WEST SUSSEX COUNTY COUNCIL CONSULTATION

TO:	<u>Arun</u> District Council <u>FAO:</u> Katie Sharp
FROM:	<u>WSCC</u> - Highways Authority
DATE:	22 April 2022
LOCATION:	Land off <u>Arundel</u> Road <u>Angmering</u> <u>BN16 4ET</u>
SUBJECT:	A/48/22/RES Approval of reserved matters following A/122/19/OUT and <u>varied</u> by A/207/21/PL pertaining to the layout, scale, appearance and landscaping for 160 No dwellings. This application is a Departure from the Development Plan and is in CIL Zone 3 and is CIL Liable as new dwellings.
DATE OF SITE VISIT:	<u>n/a</u>
RECOMMENDATION:	More Information / Modification
<u>S106</u> CONTRIBUTION TOTAL:	<u>n/a</u>

The application is for reserve matters following outline approval and access approval of A/122/19/OUT and varied by A/207/21/PL at Land off Arundel Road, Angmering

Road Typologies plan

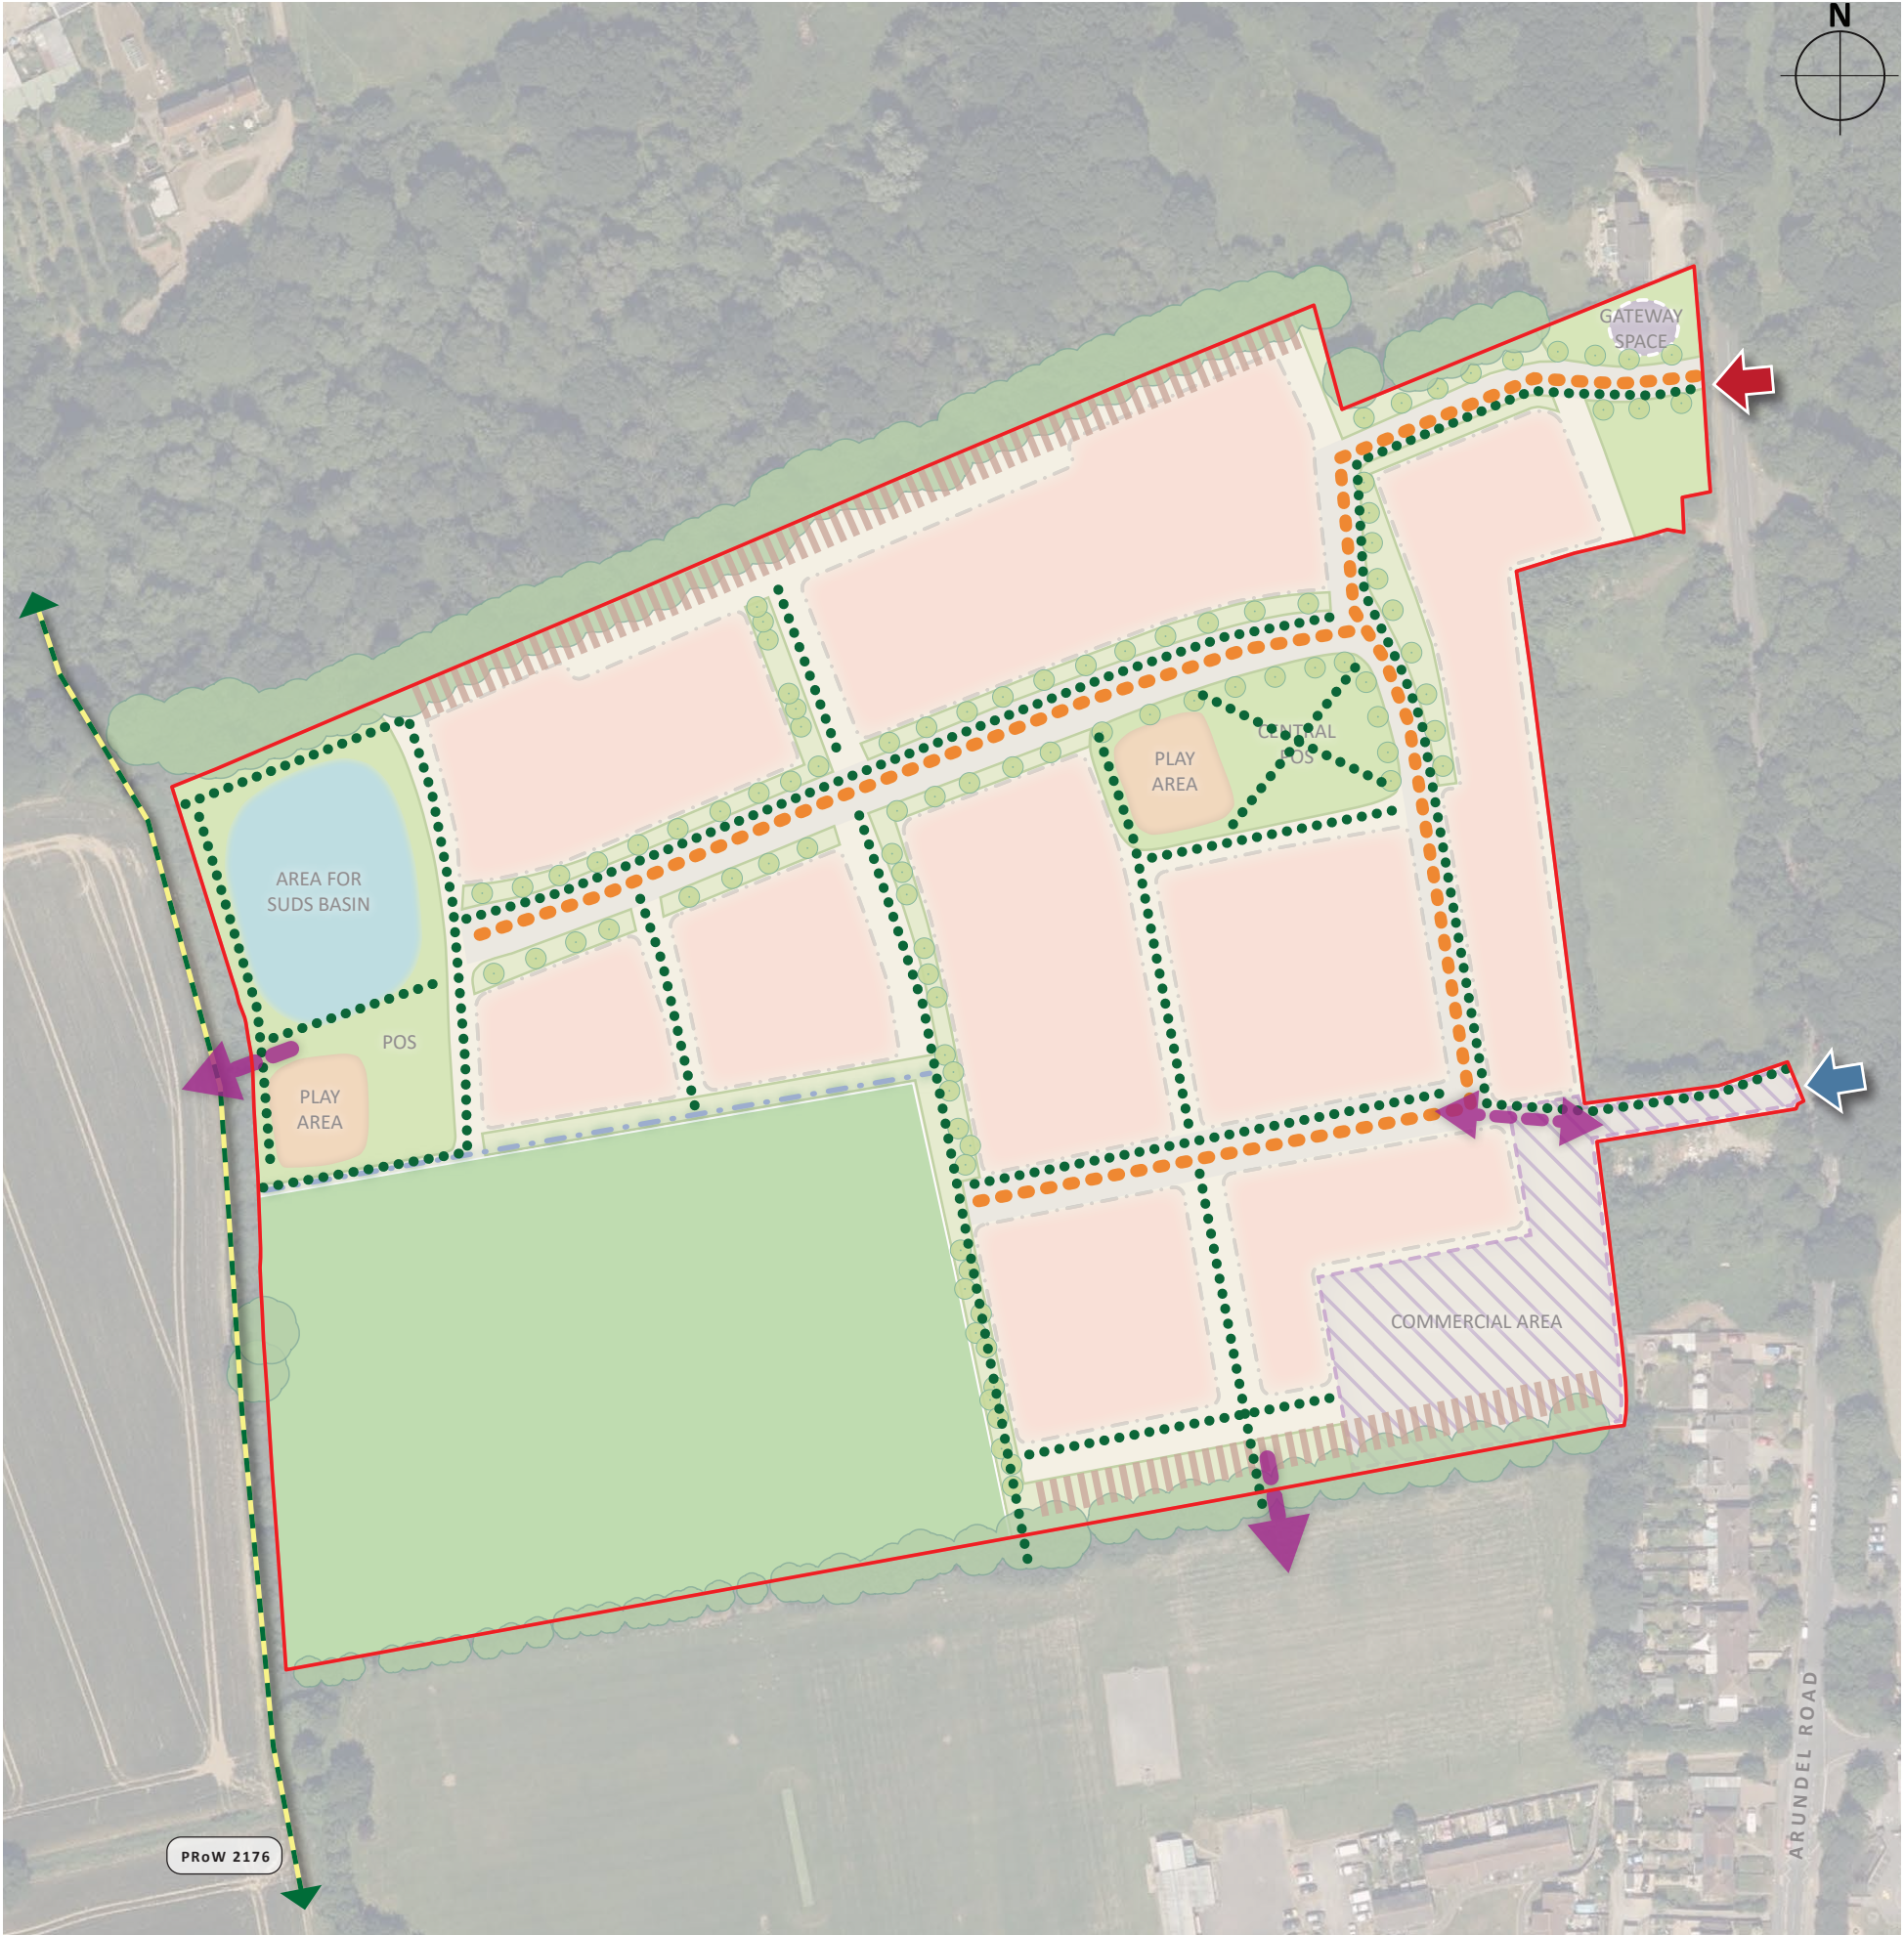
No vehicular access is possible between the northern and southern accesses internal of the site. The scheme may benefit from an emergency access link should either become blocked.

No details are shown as to how a pedestrian and cycle connection could be made to allow the residential element of the development to utilise the southern access

No crossing point to be provided to allow north/south movement close to the northern access.

At the outline stage indicative plans showed a ped cycle route to the north of the POS, in the RM application the only a grass link is provided. Further information should be provided onto any further connections into the POS or proposed future footway/cycleway provision within the POS.
